# Boston Alternative Energy Facility

## Statement of Common Ground between Alternative Use Boston Projects Limited and Boston Borough Council

Planning Inspectorate Reference Number: EN010095

Date: ~~December 2021~~ February 2022

TITLE  
 BOSTON ALTERNATIVE ENERGY FACILITY  
 DEVELOPMENT CONSENT ORDER  
 Regulation 5(2)(c) - Illustrative Landscape Plans  
 BOSTON BOROUGH COUNCIL  
 SHEET 1 OF 8

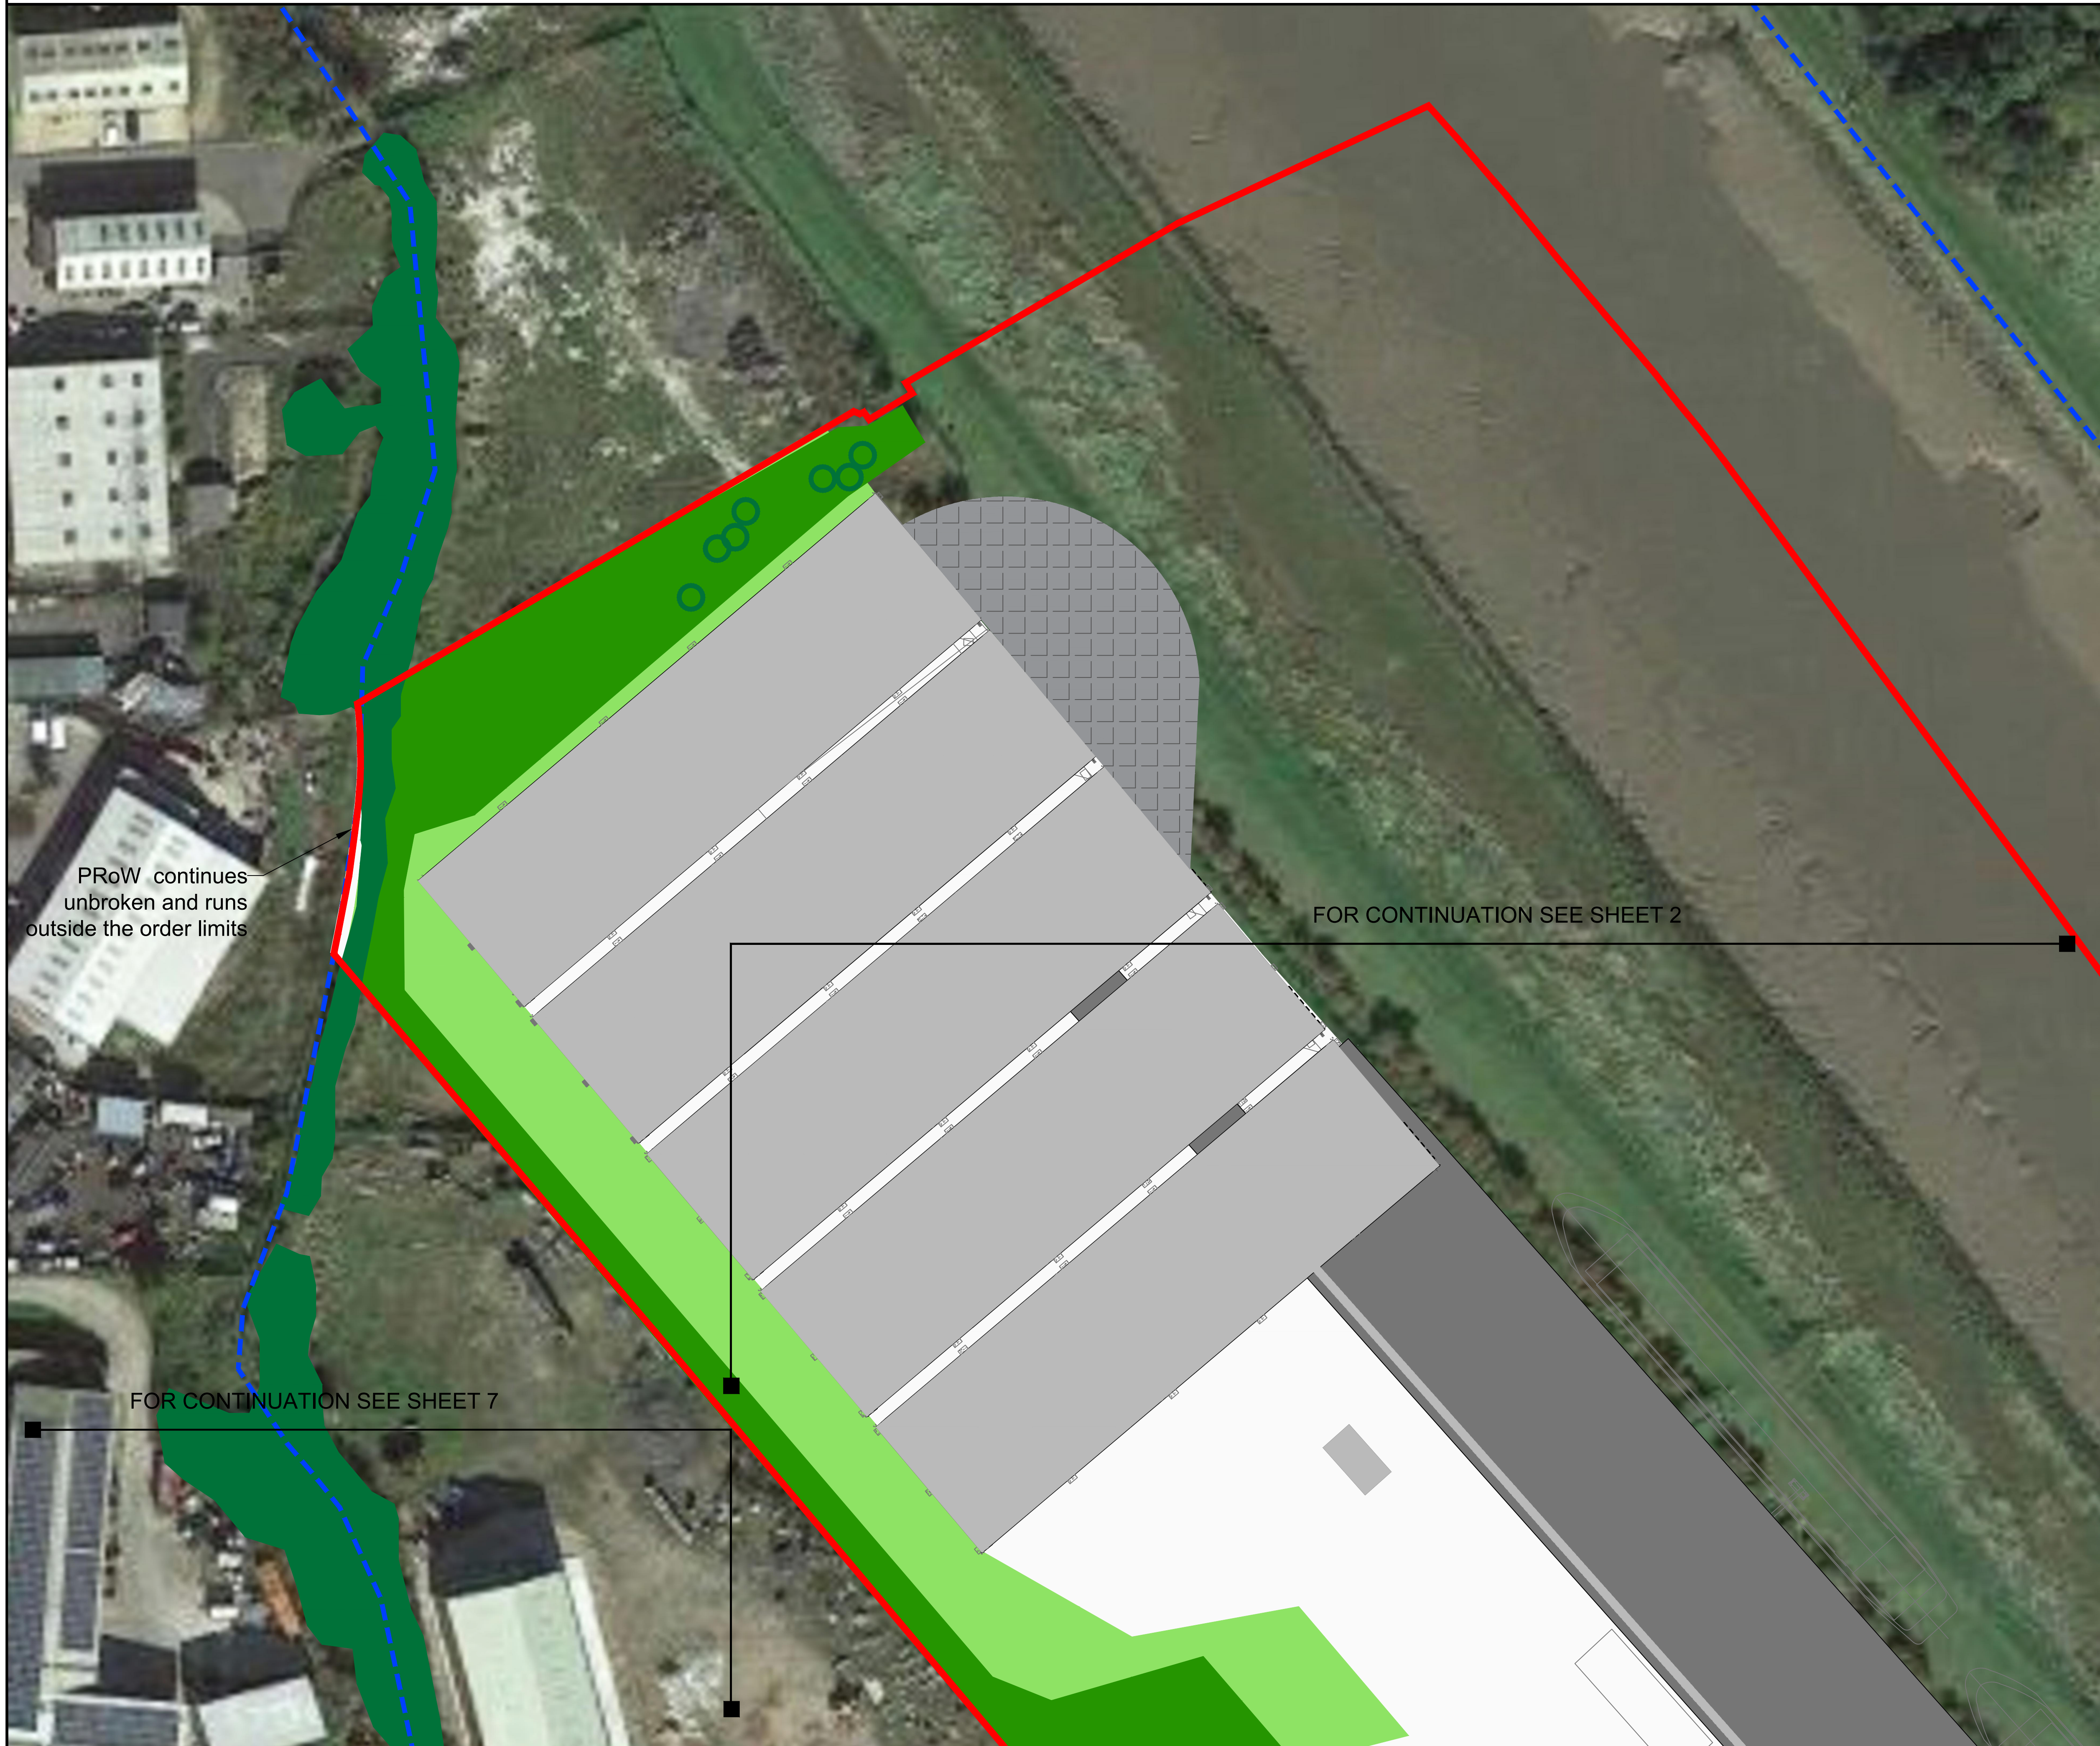
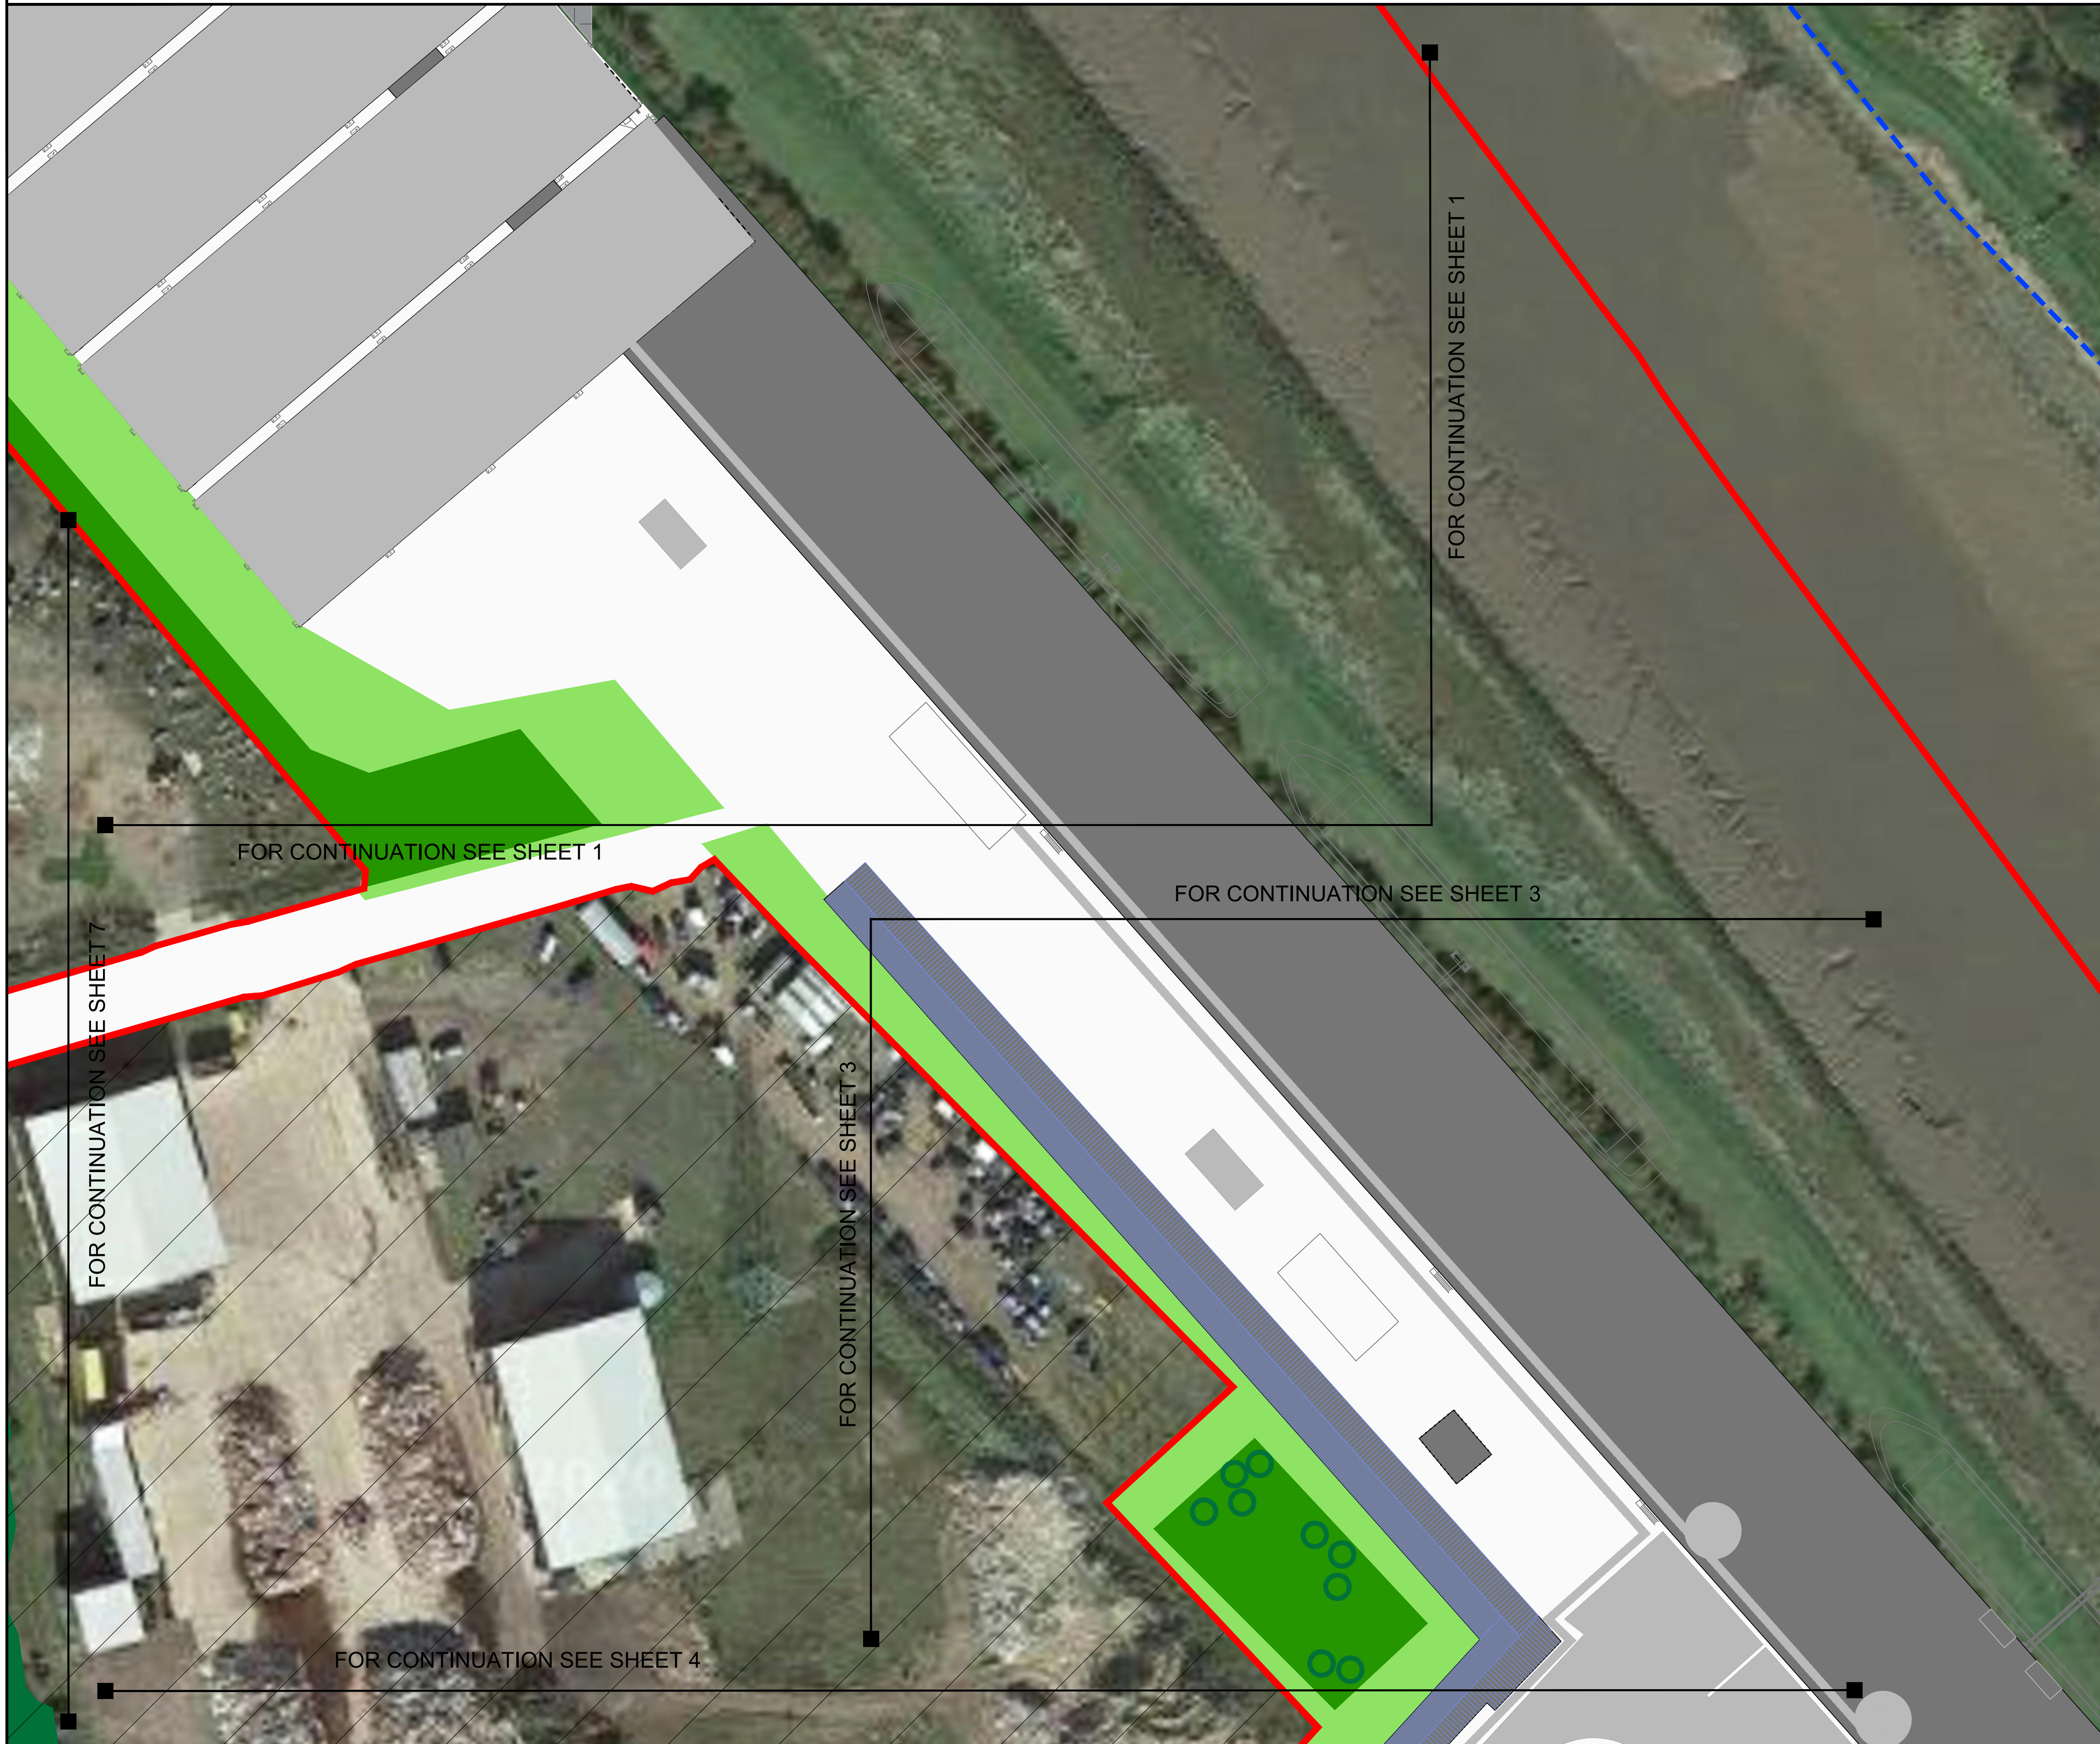
SoCG Reference	Document Reference	Topic	BBC's Position	AUBP's Position	Status
			submissions have been lodged formally, and a S106 concluded.		
BBC 2.4	Outline Landscape and Ecological Management Plan (Doc ref 7.4, APP-123)	Planting	<p>Planting should be moved forward in the programme and inspections should be carried out more frequently than annually. The planting proposed is described in the OLEMS could be adjusted to provide enhanced carbon and particulate removal.</p> <p>The Council has reviewed the responses to date on this point. We note the steps taken by AUBP to address and that there are proposals for mitigation being presented. In general terms these are acceptable. There are some inconsistencies in the document –            Para 10.7.2 does say monthly inspections. There are instances in paras 10.8.2, 10.10.2 10.11.2 that refer to annual removal of rubbish and repair of vandalism so my be inconsistencies that need reviewing.</p> <p>It is likely that this matter will be agreed by a subsequent deadline once further submissions have been lodged formally, requirements finalised, and a S106 concluded.</p>	<p>The updated OLEMS was submitted to the Examination at Deadline 3 (document reference 7.4(1), REP3-007), includes a monthly inspection of vandalism and fly tipping. Any inconsistencies in the OLEMS will be checked and amended as necessary.</p> <p>The Applicant will agree the final planting within the final LEMS.</p>	Under discussion
